Application for a Non-Material Amendment Following a Grant of Planning Permission

Erection of a single storey rear and two storey side extension along with construction of a front porch. Works to include erection of a detached pool house, construction of an outdoor pool along with the formation of a new access and associated landscaping works.

21/03147/HHD

- Change external cladding material for the proposed rear single-story extension to timber cladding.
- Minor changes to window opening sizes

Proposed Elevations

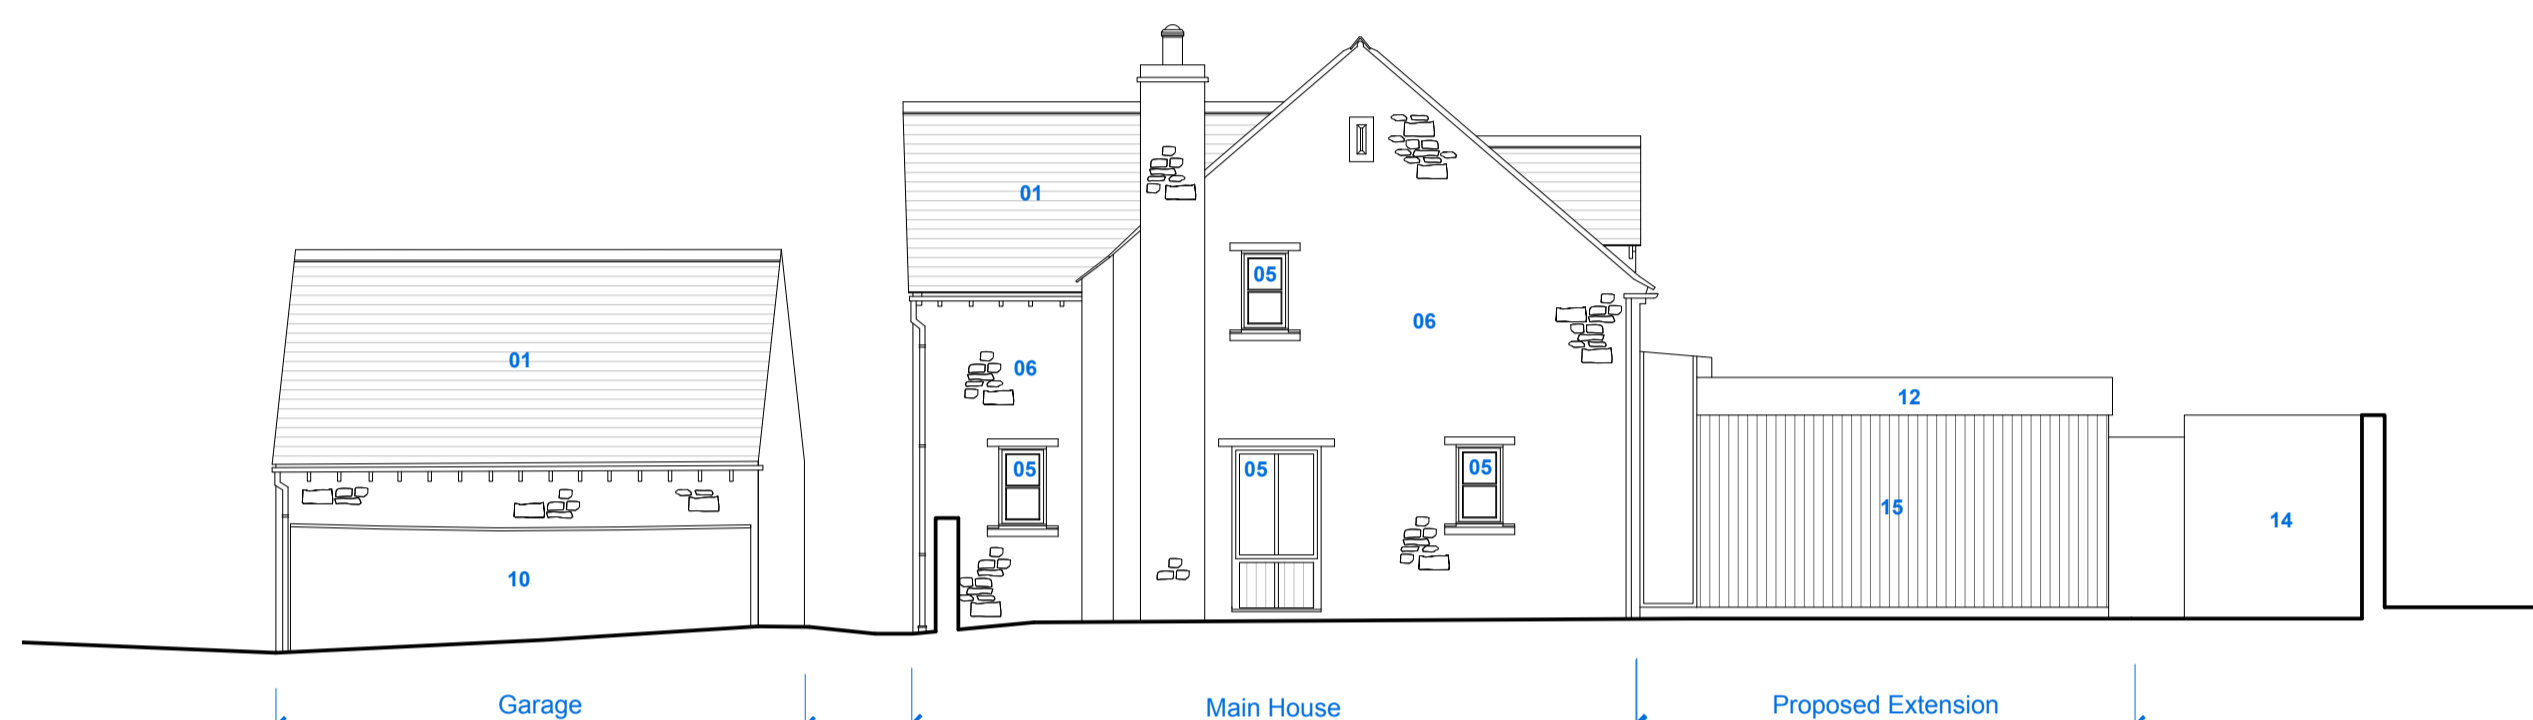
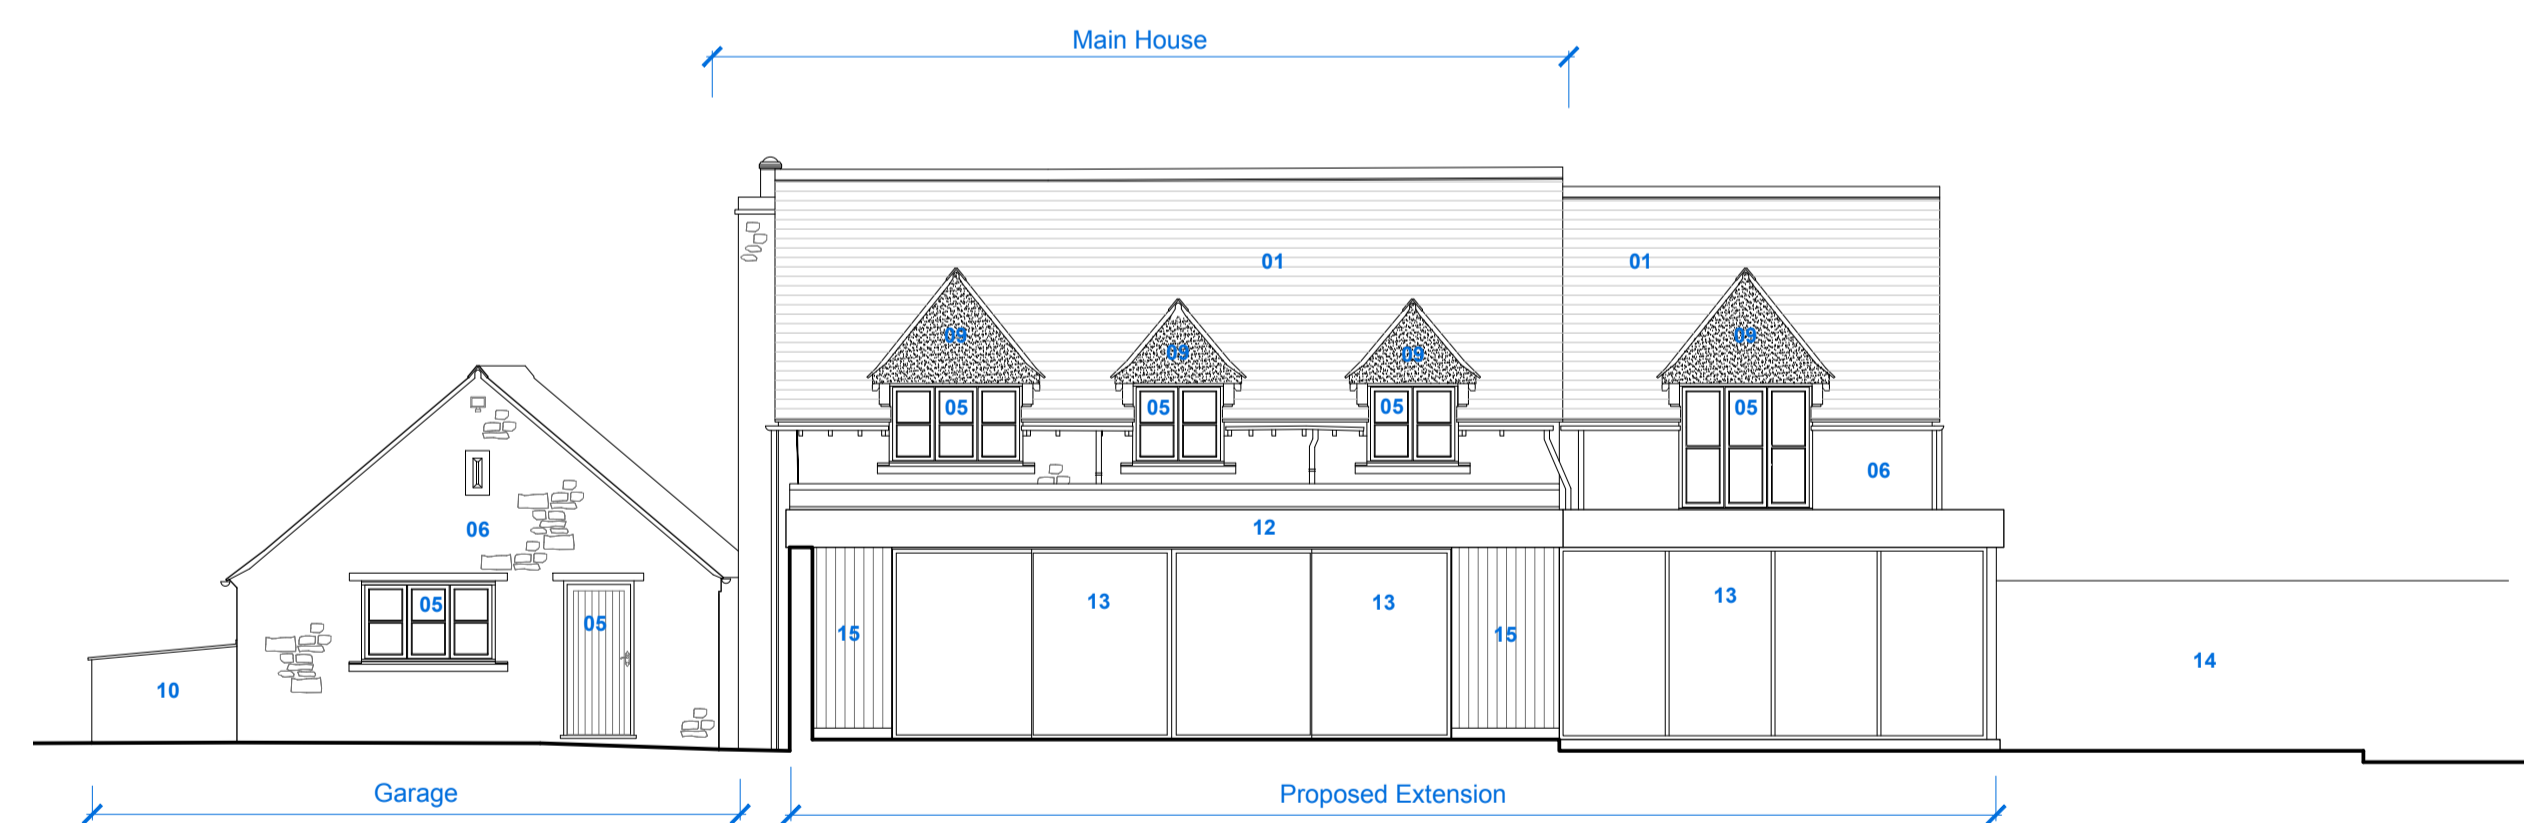
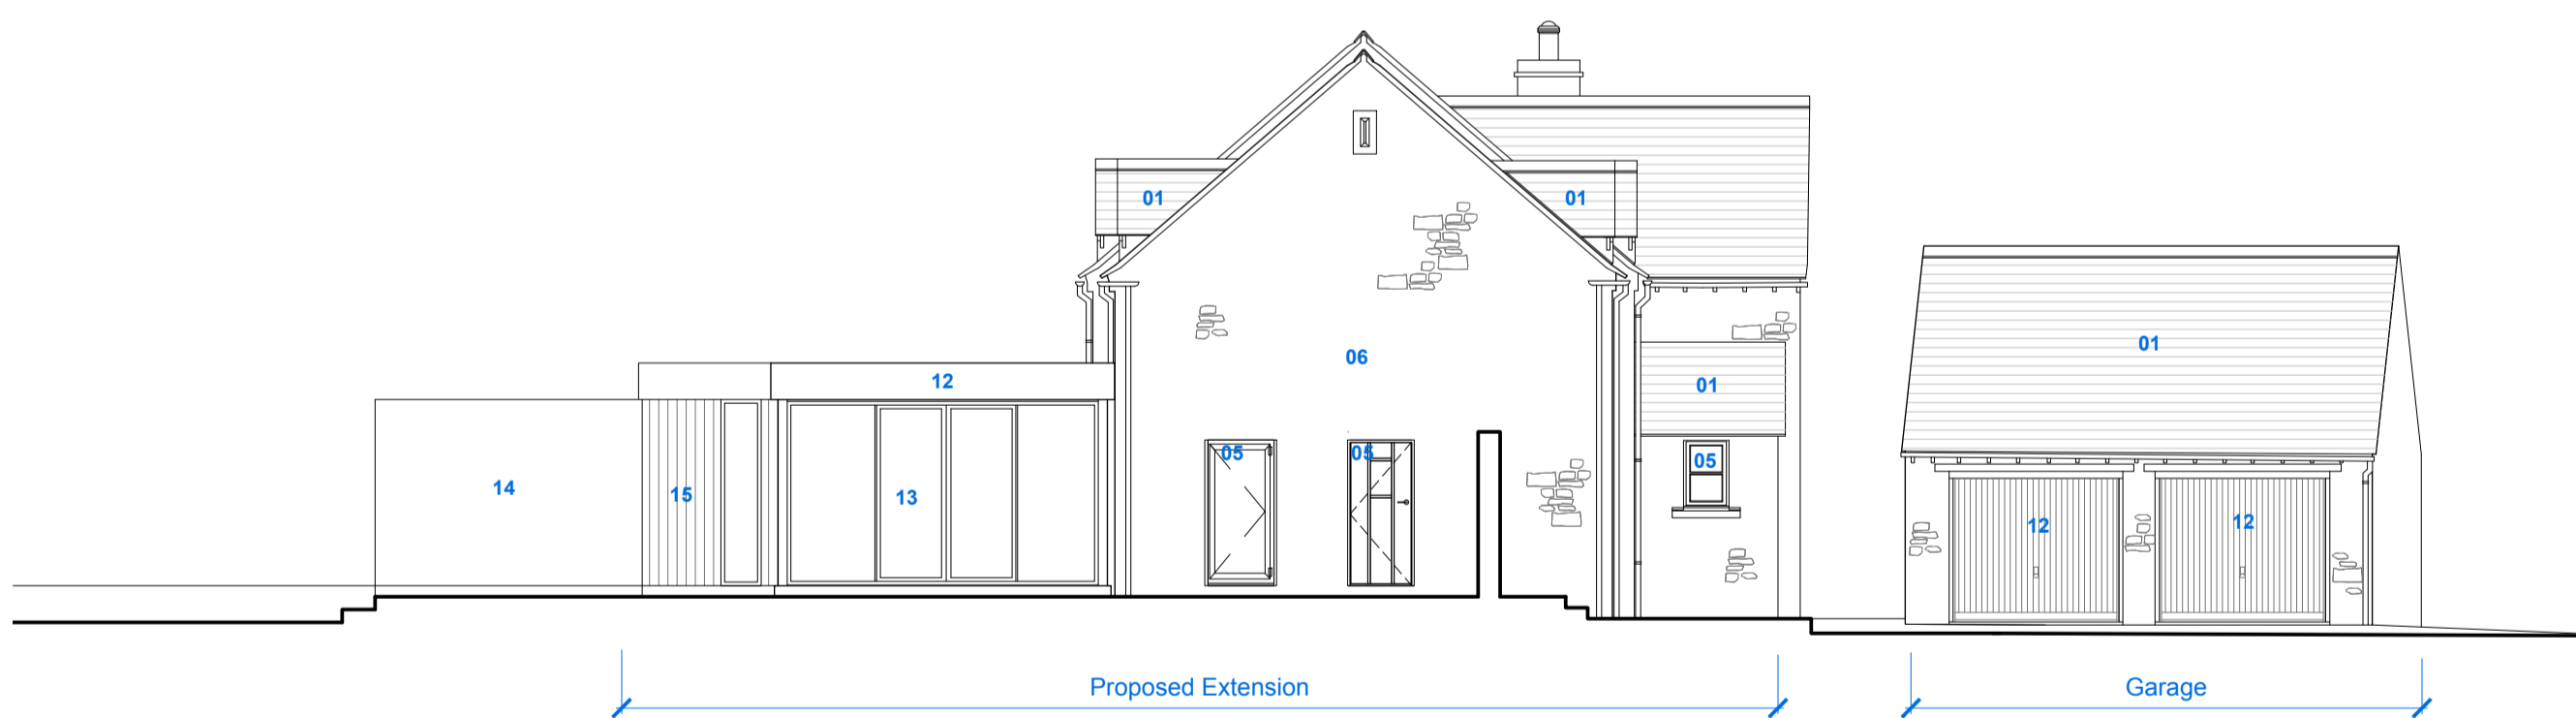
Update for insulation to meet the changing building regulations.
